25 August 2014

**RE: SSD 6123 — The University of Sydney Improvement Program**

CURRENT SEWER NETWORK

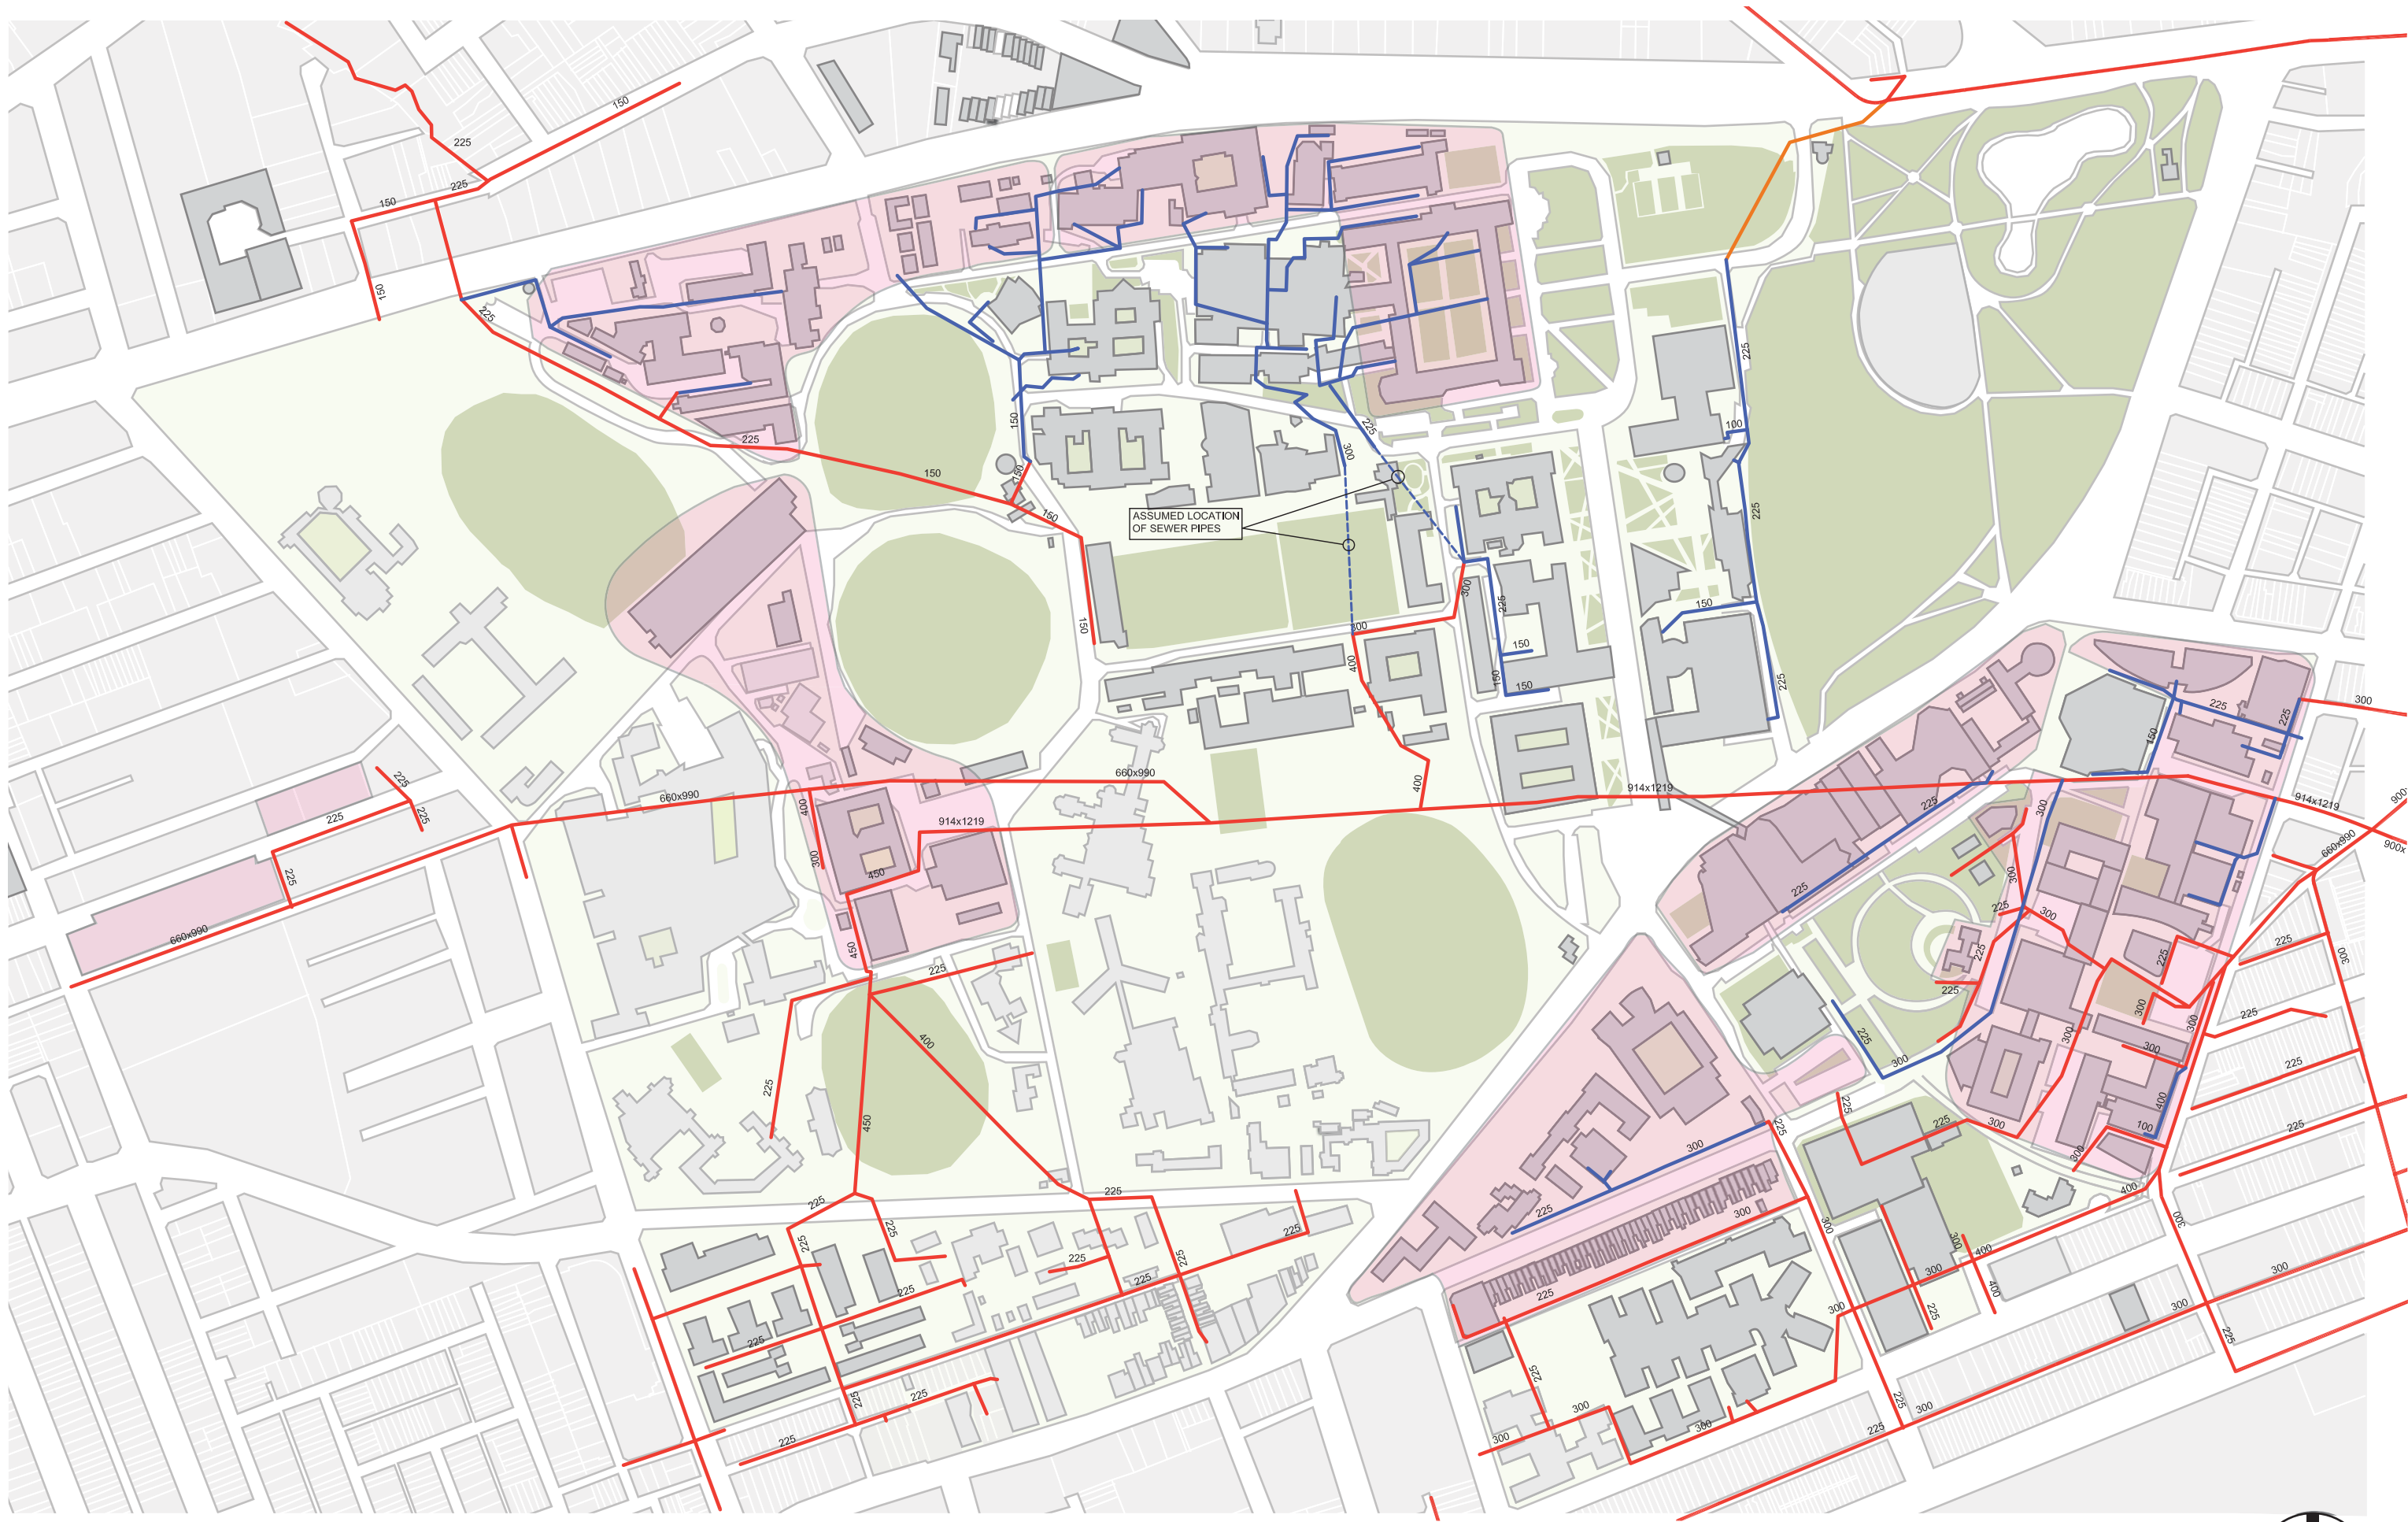
- Most of the submitted drawings illustrate that Sydney Water's stormwater assets are identified as university owned stormwater assets, and University's stormwater assets are identified as Sydney Water's stormwater assets
- Legends of these drawings are to be amended to ensure the ownership of the stormwater assets are identified correctly.
